Arborist Report

To: Mina Laban
Site: 10 Brook Bay Rd, Mercer Island, WA 98040
Re: Preliminary - Tree Inventory for Development
Date: October 9, 2023
Project Arborist: Charlie Vogelheim
ISA Certified Arborist #PN-9375A
Qualified Tree Risk Assessor
Referenced Documents: Critical Area Study and Conceptual Mitigation Plan for Laban Remodel 10 Brook Bay Road. Wetland Resources Inc. 4.25.23.
Laban Remodel Corrections 1. Floisand Studio. 10.10.23.
Laban Residence Siteplan. Pacific Stormwater.
Attached: Table of Trees
Tree Site Map
Tree Retention Worksheet

DEMO SITE PLAN

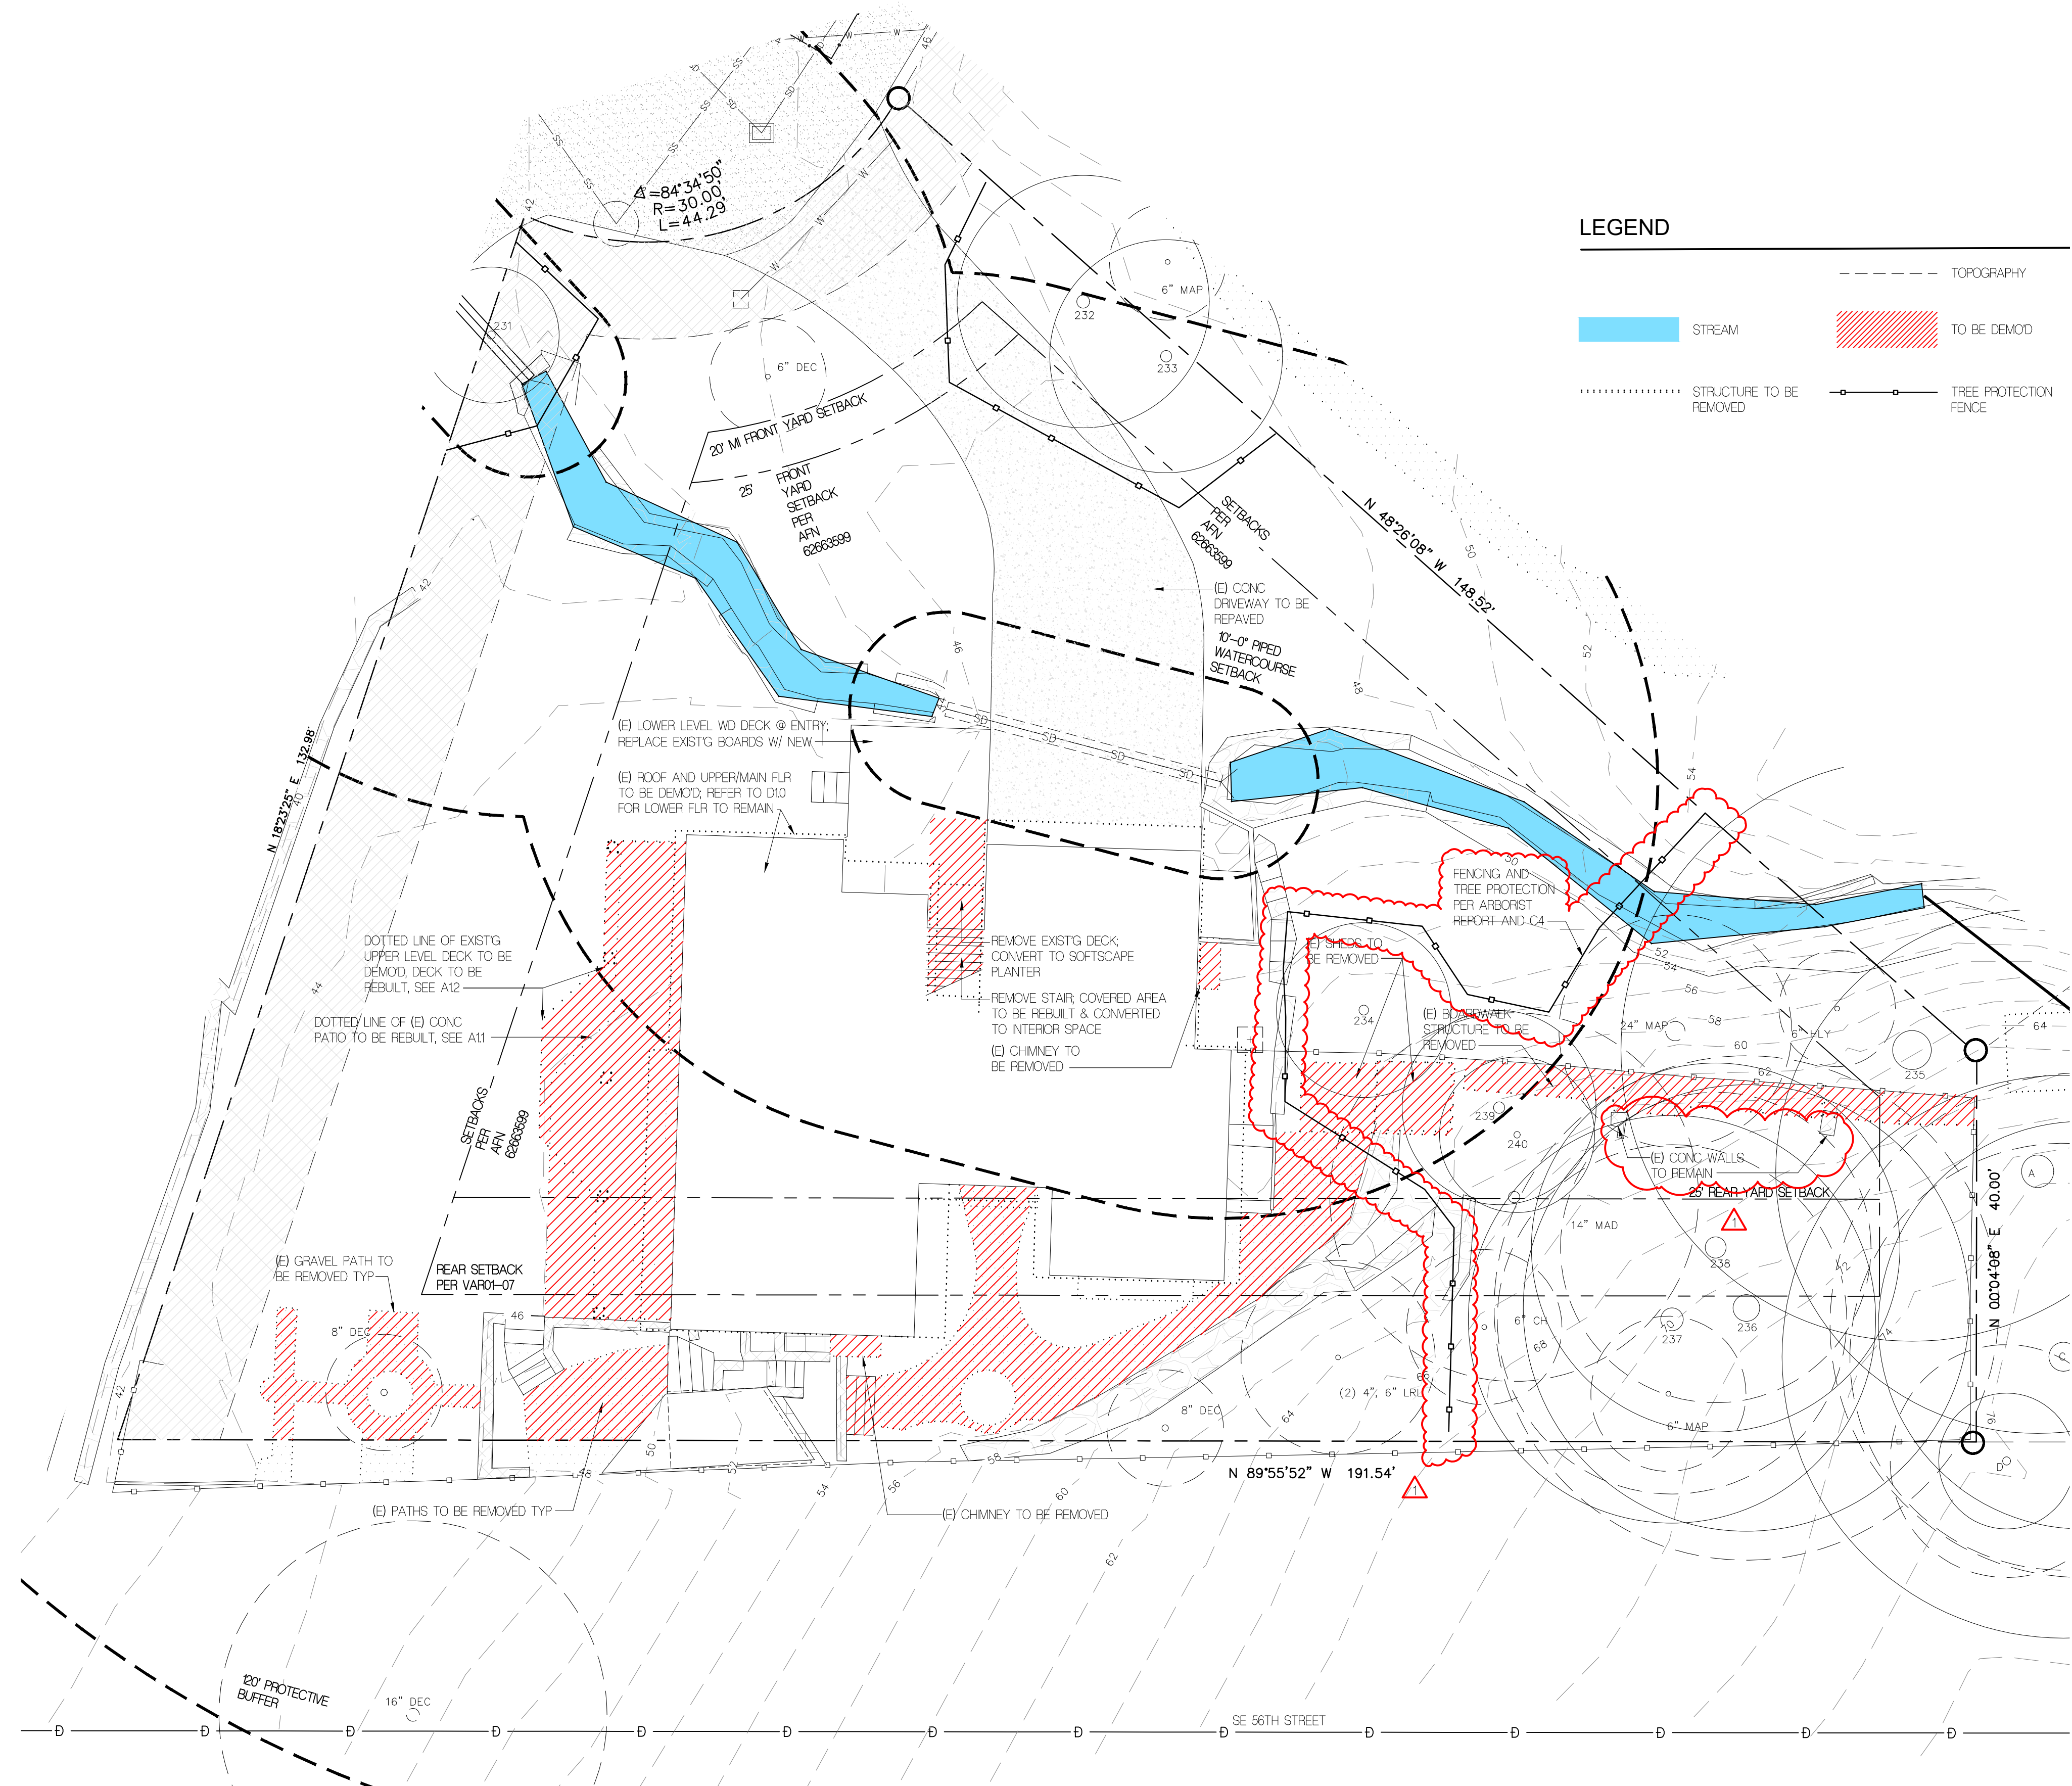
The Demo Site Plan for this project indicates that sheds, the wall, and concrete supports on the east side of the property will be removed. This work will happen within the RLOD of regulated tree 234 and exceptional trees 235, 236, 238, 239, 240, A, and B. Removal of the concrete supports will likely impact roots and we recommend they be abandoned on-site. Methods that may disturb or impact the soil, such as the use of heavy machines, shall be avoided when removing these structures. Bare soil shall be covered with four inches of arborist woodchip mulch and irrigated during the dry summer season. The project arborist shall review the demolition methods and an arborist should be present during the removal of these structures to monitor, document, and direct tree protection measures. Appendix F includes further general tree protection measures. Tree protection fencing shall be replaced at the edge of the RLODs of these trees as soon as the work is completed.

- Review special tree protection measures with Tree Solutions Inc., for trees that may be impacted by the shed and wall removal on the east side of the property.

- Have an arborist present to monitor, document, and direct tree protection measures during the removal of the shed and the wall.
- All off-site trees must be protected during construction. See specifications in Appendix F.
